CITY OF ALBUQUERQUE

April 25, 2019

**Re: T and M Self Storage
Erosion and Sediment Control Plan
Engineer's Stamp Date 4-11-19 (H10E032)**

EROSION CONTROL PLAN

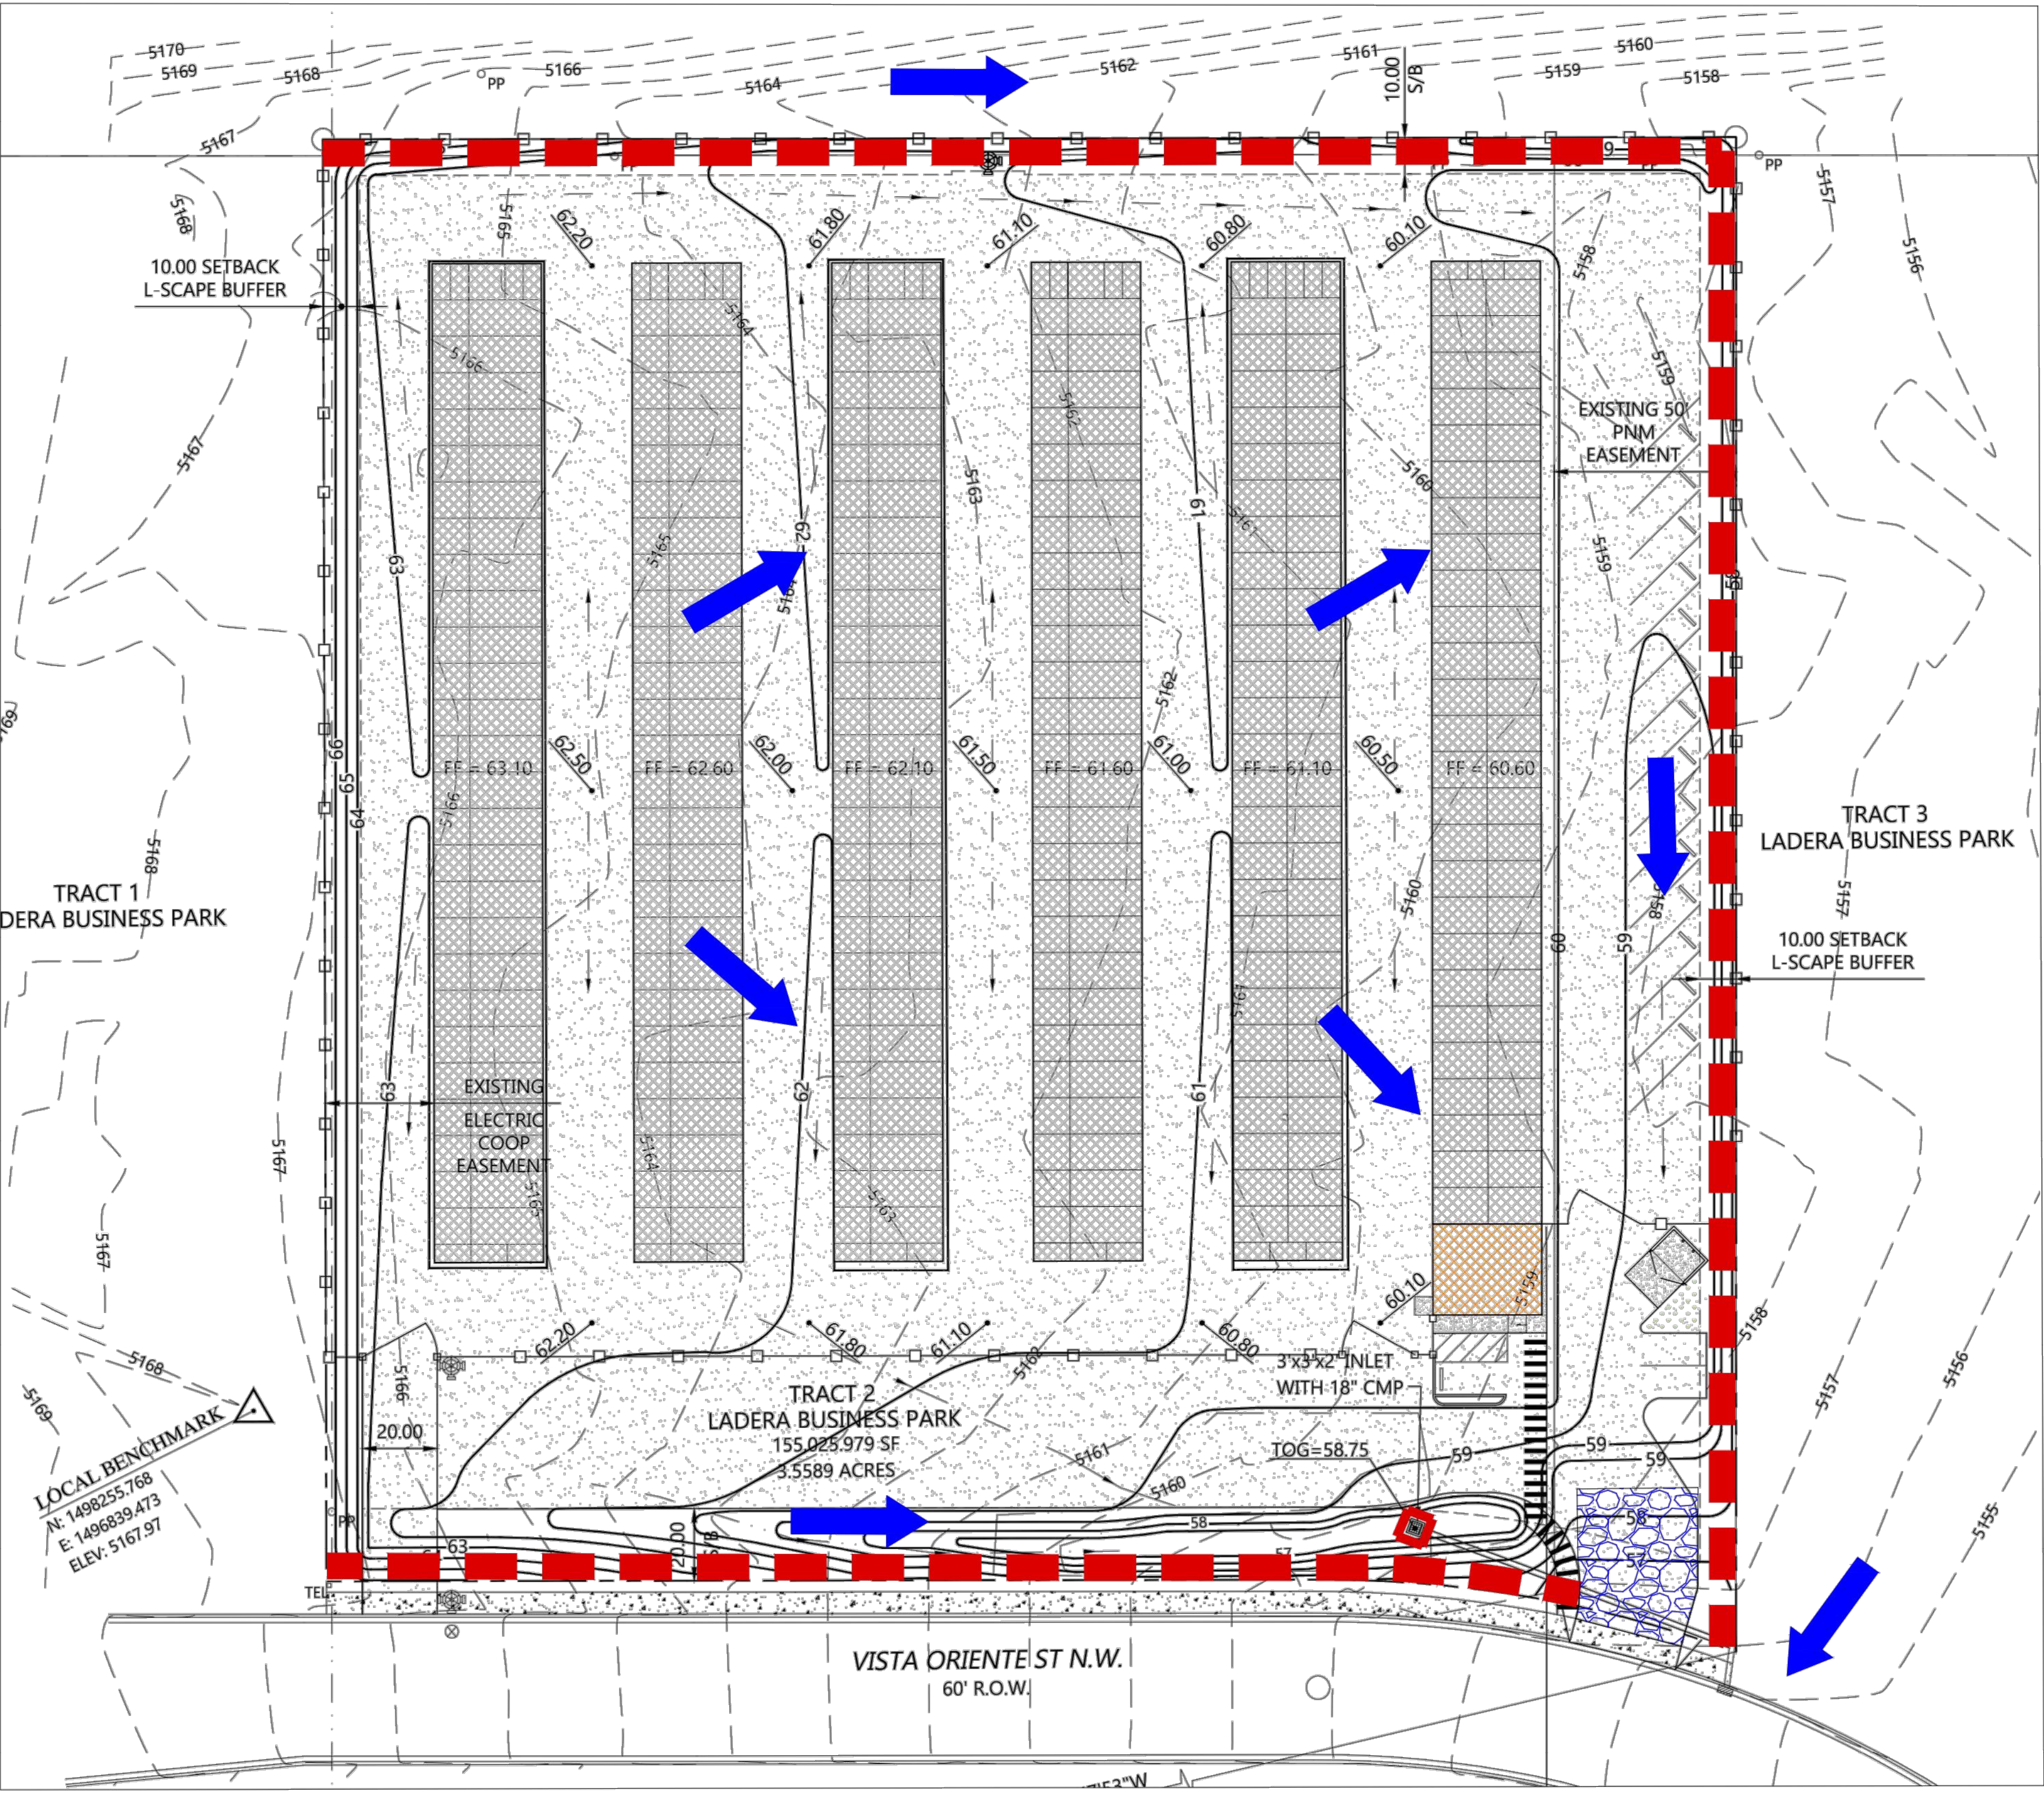
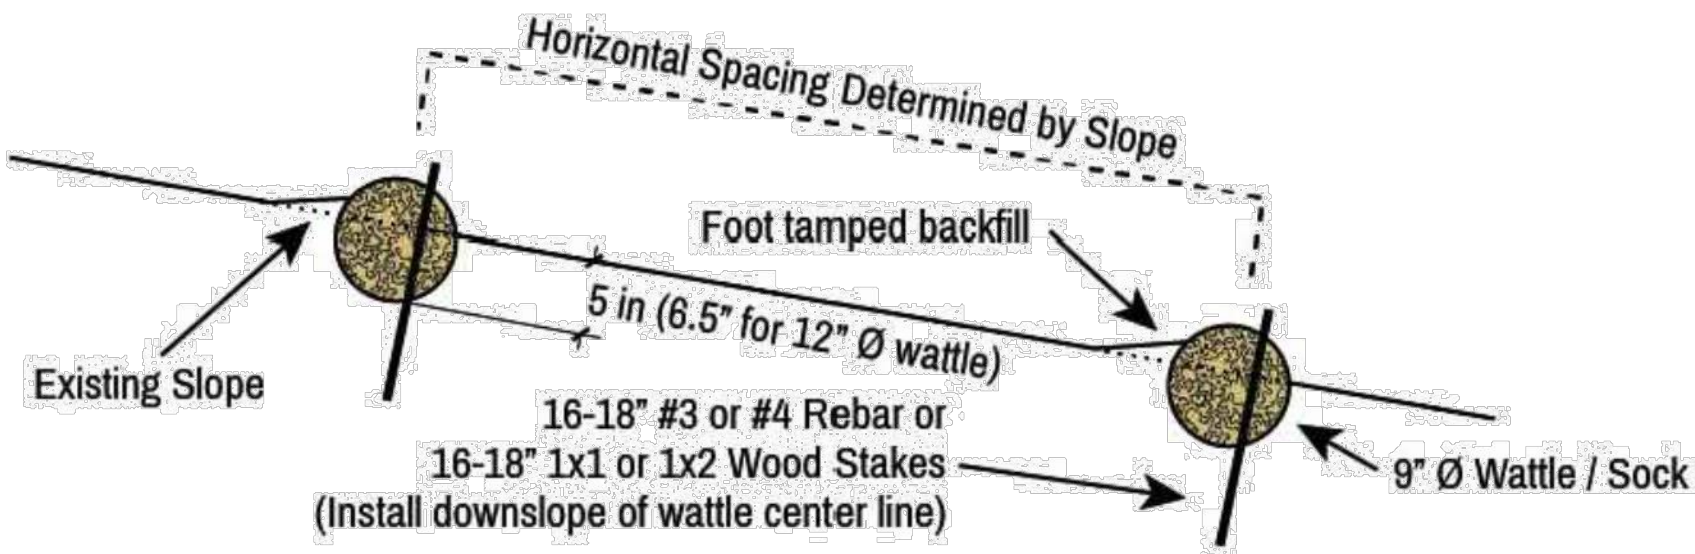
1. The soil erosion berm is to be compacted. Level of compaction can be achieved by driving on the berm with earth-moving equipment or a tamper. The test to see if it is compacted adequately is that an inspector will not sink into it when stepped/walked on.

2. Minimum size for wood poles for silt fence is 2"x 2" (actual 1.5" x 1.5").
